Review Response

Date: 06/04/2024

Project Name: Cui Dock Repair

Response To: SHL23-057 SUB1

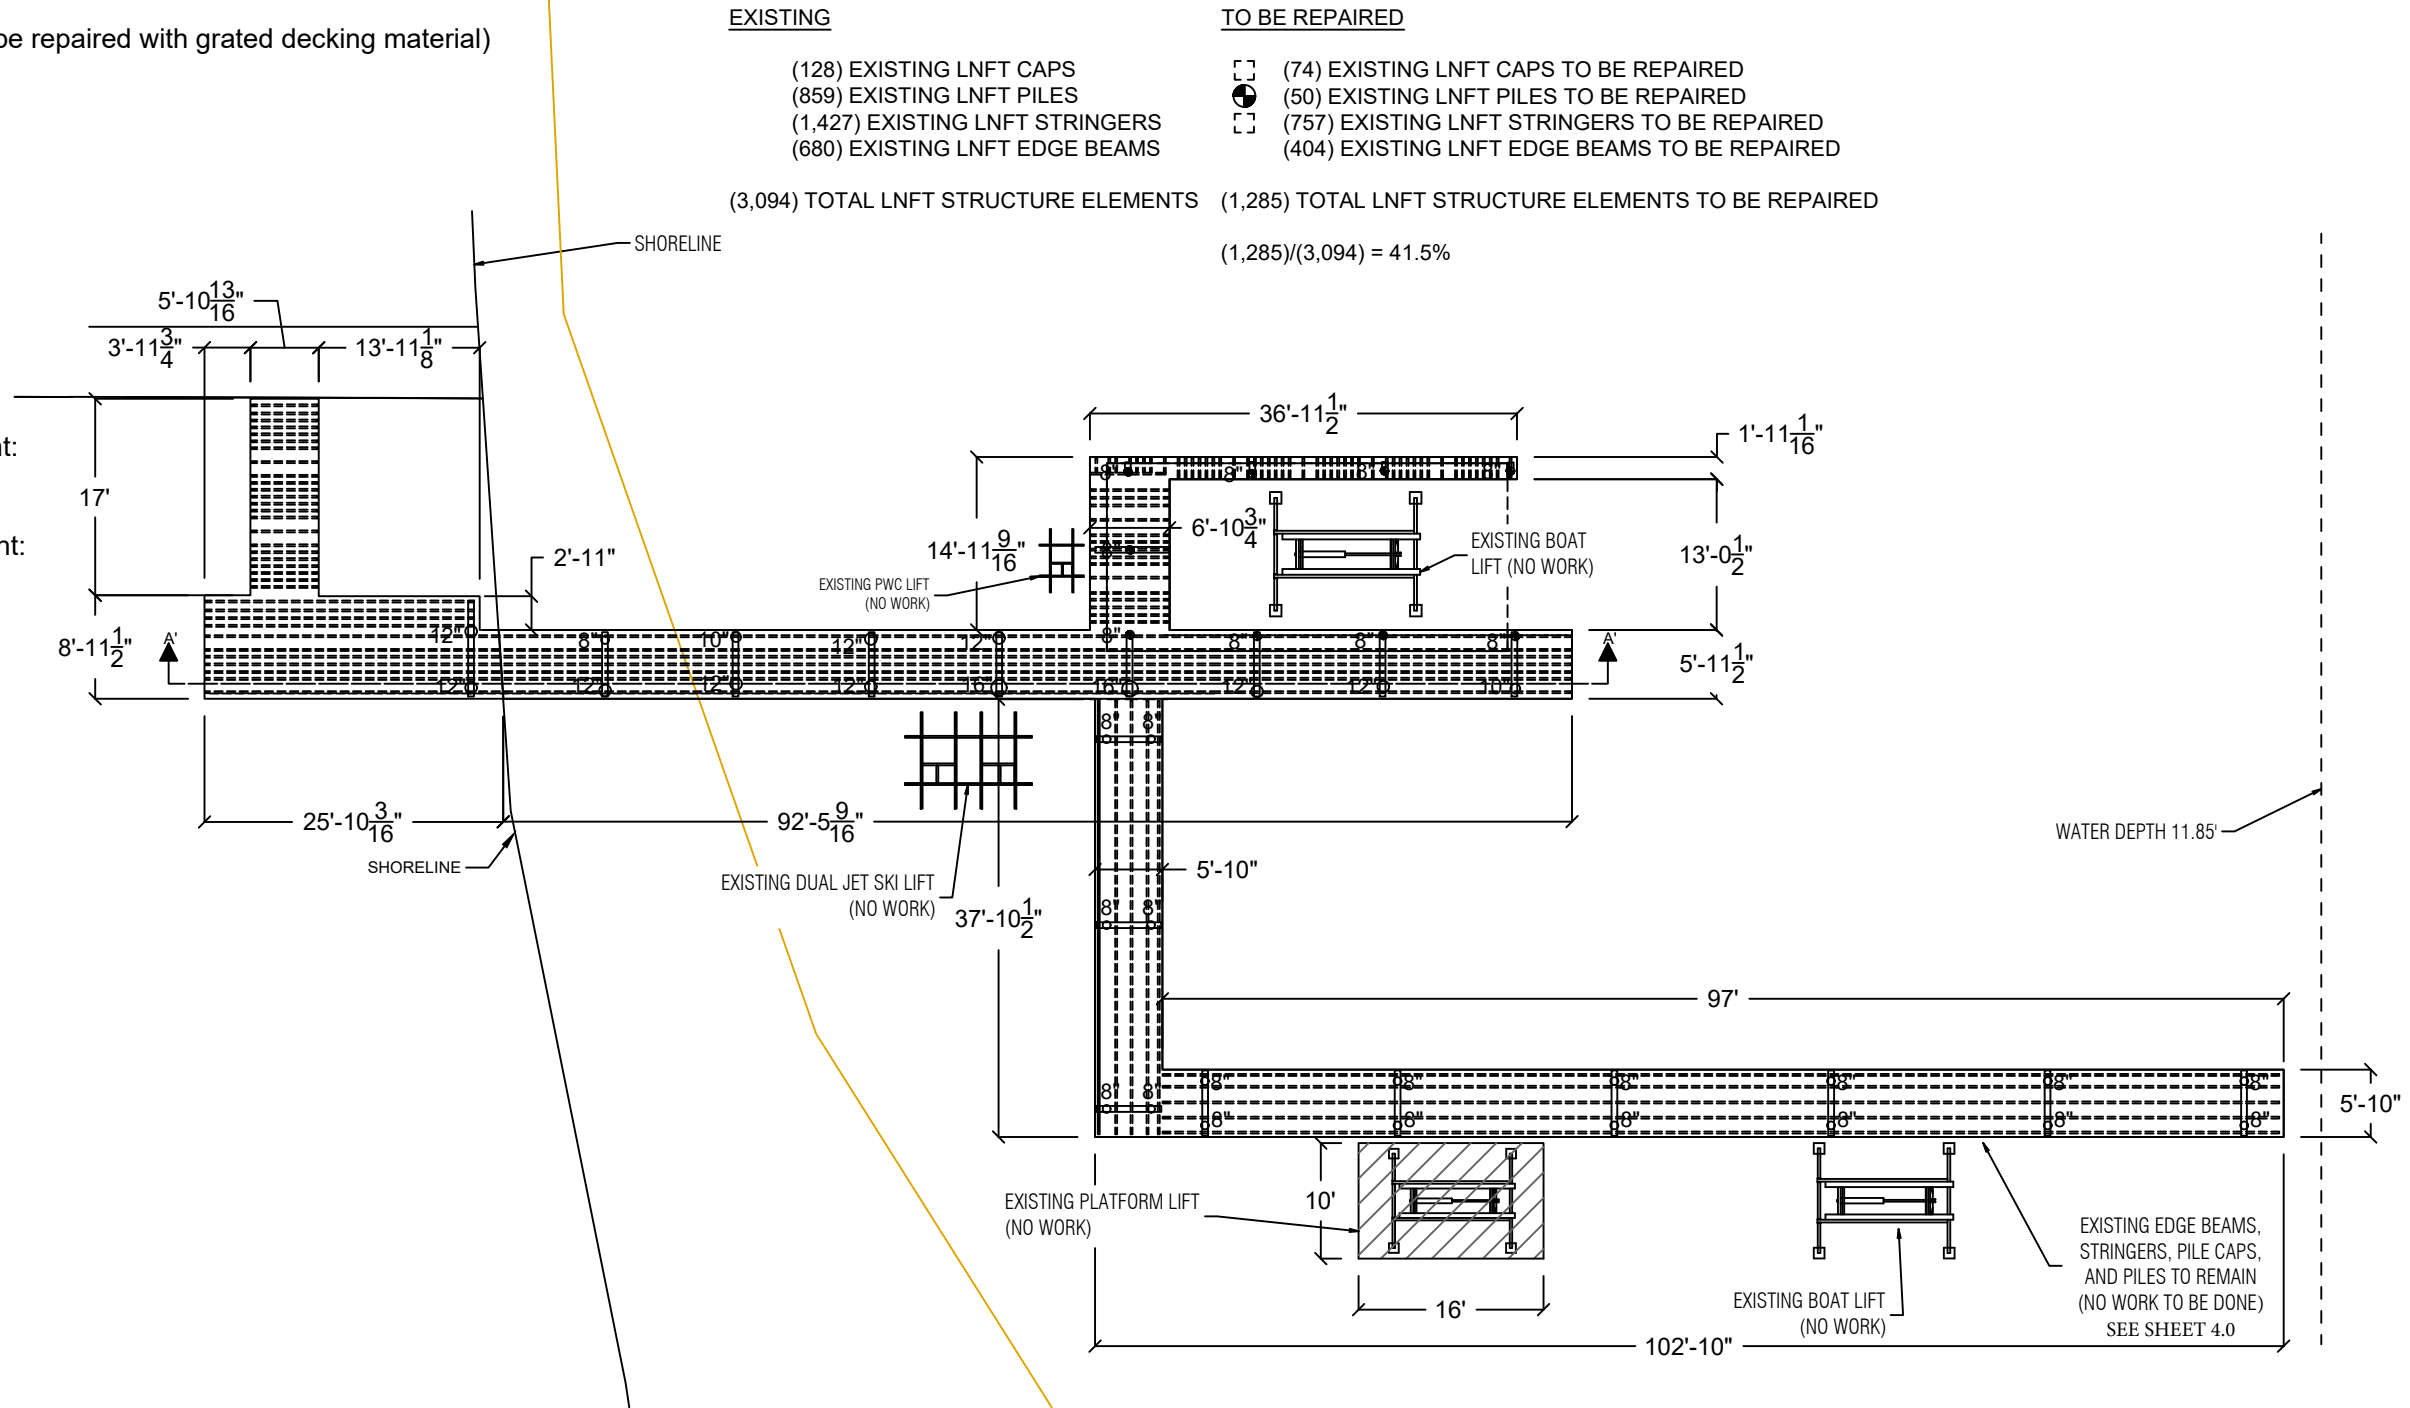
1. MICC 19.13.050(A) Pertains to "Development" landward of OHWM. Per MIMC 15.11.010 - Definitions. " *Development* means new development, redevelopment, or both." " *Redevelopment* means, on a site that is already substantially developed (i.e., has 35 percent or more of existing hard surface coverage), the creation or addition of hard surfaces; the expansion of a building footprint or addition or replacement of a structure; structural development including construction, installation or expansion of a building or other structure; replacement of hard surface that is not part of a routine maintenance activity; and land disturbing activities."

- Our plan fall under routine maintenance activities and does not trigger the impervious area calculation requirement. For clarity I have added a note indicating the square footage of the legally established impervious area and an indication that we are reducing that area bringing the square footage further into compliance with modern code.

2. Caps- The plan set indicated the area of the pier on which no work is to be done. This area shall have no caps stringers piles or edge beams to be replaced. See indicated hatched area on proposal view, for area to be worked on. As well as the callout on page 7.

**S3** PILE SPLICE - STEEL SPLICE  
SCALE: 1/2" - 1"

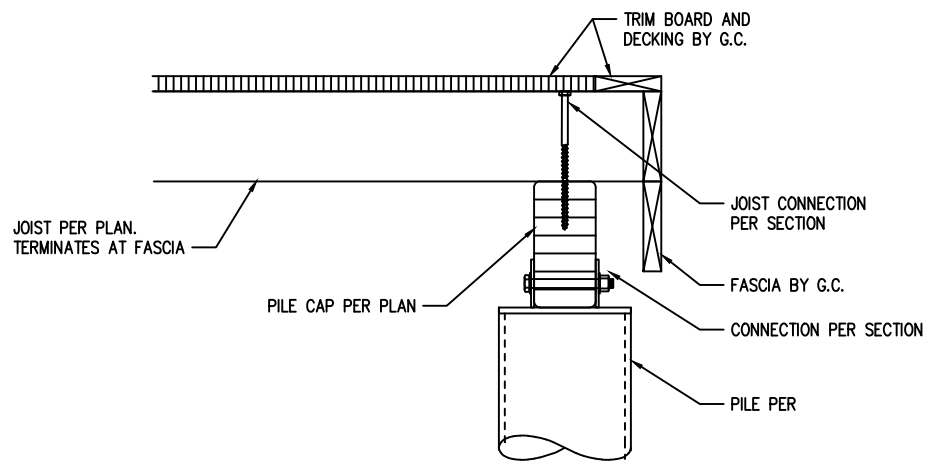
3. Stringers- See above.
4. Piles- The piles to be repaired are indicated in the legend. The pile repair details indicated the methodology by which the piles are repaired. A portion of the pile is cut and replaced with steel averaging out to ~5.5' of pile for each of the nine piles to be repaired.
